Provide more detailed framing plans. It is difficult to differentiate between the existing and proposed joists. Clarify if plans have been reviewed by a structural engineer and have structural drawings stamped by engineer.

**90 MORNING STREET, PORTLAND, ME**

**ATTIC FLOOR CEILING PLAN**

S 1.0
REVISED
04 15 16

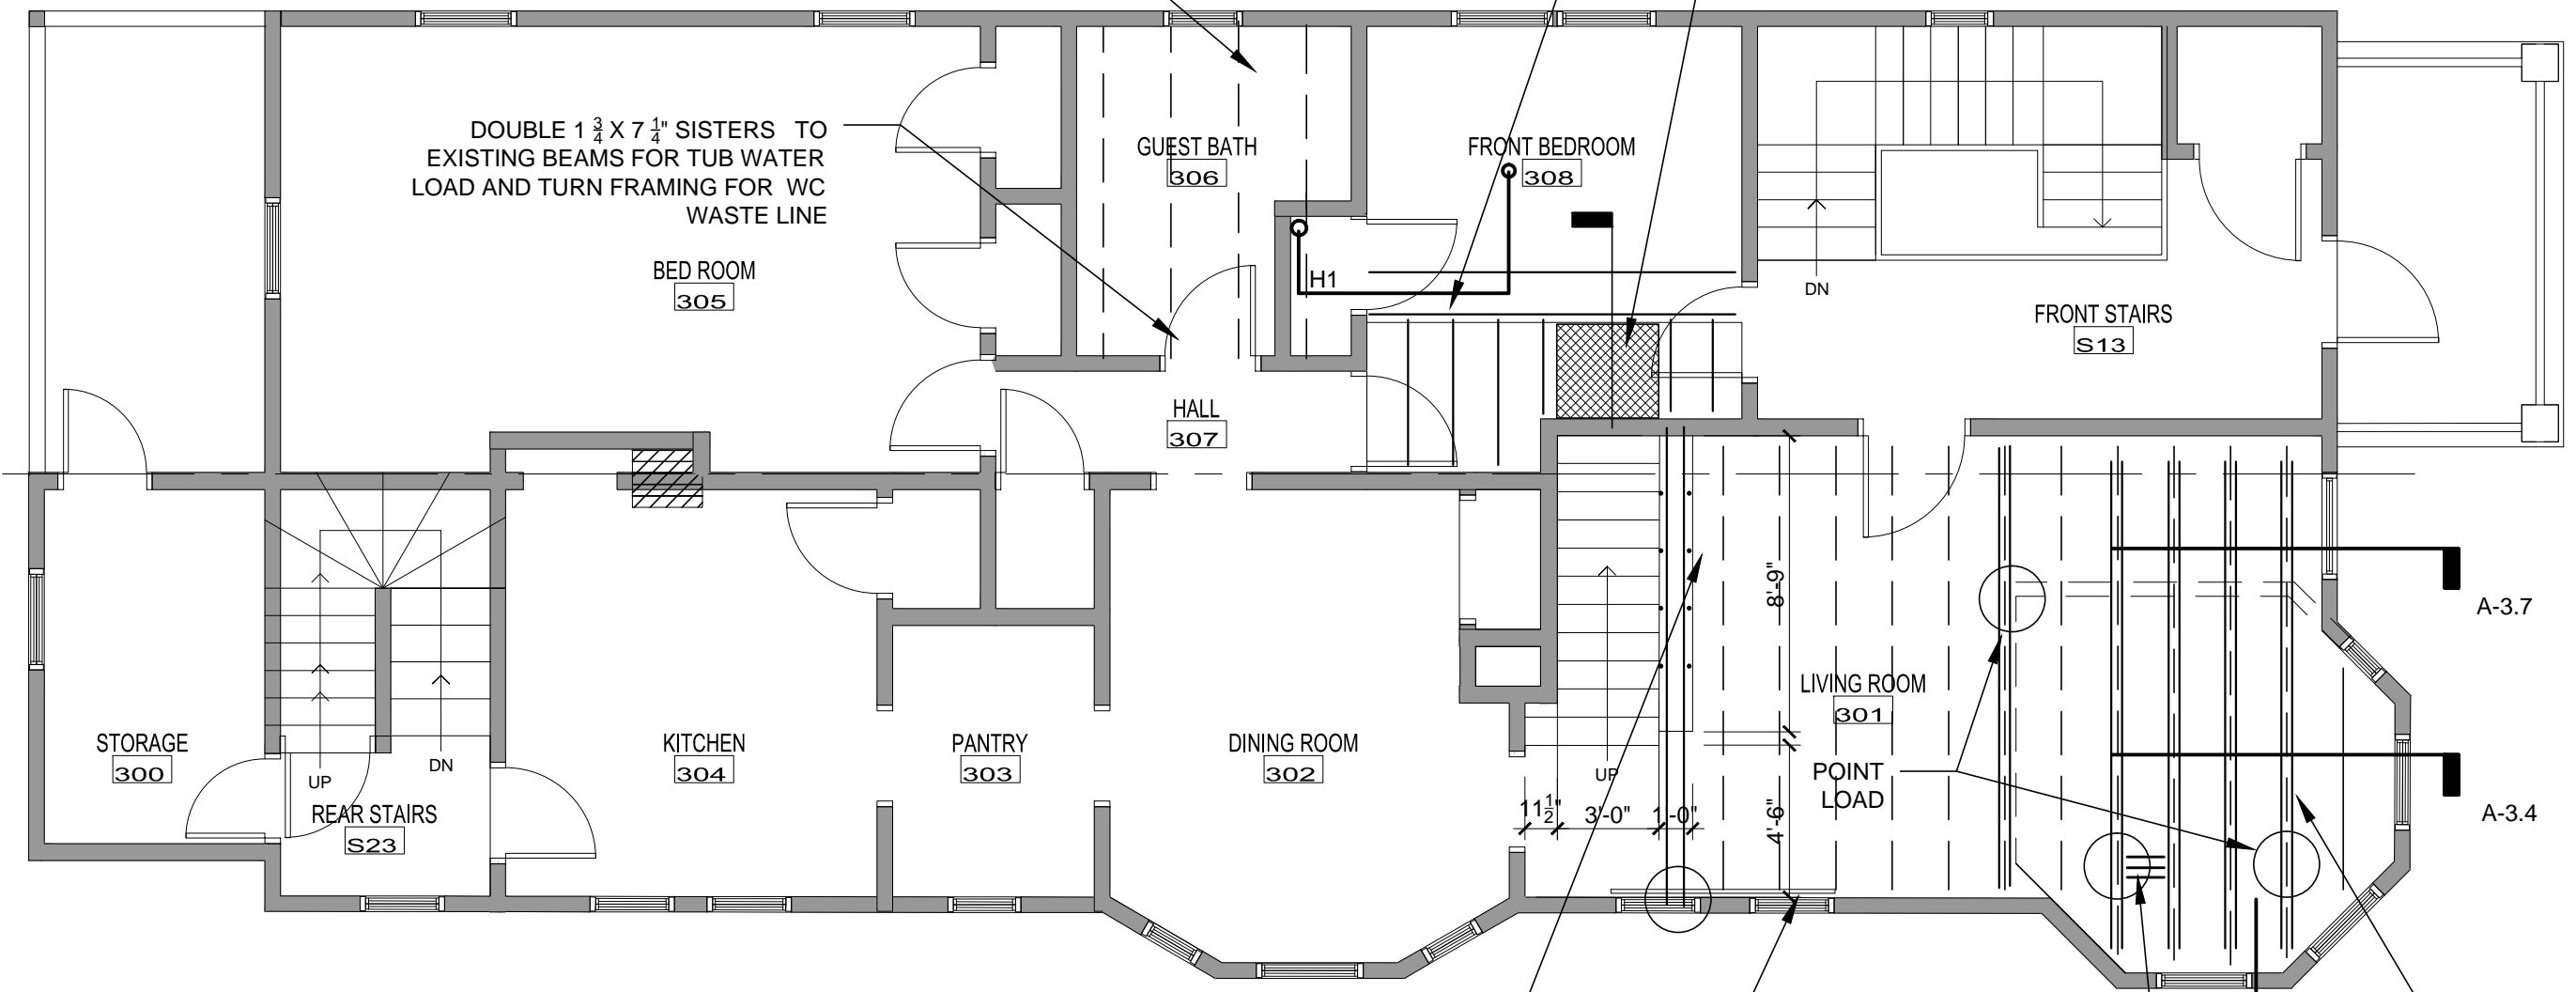
Provide specifications for LVL joists.
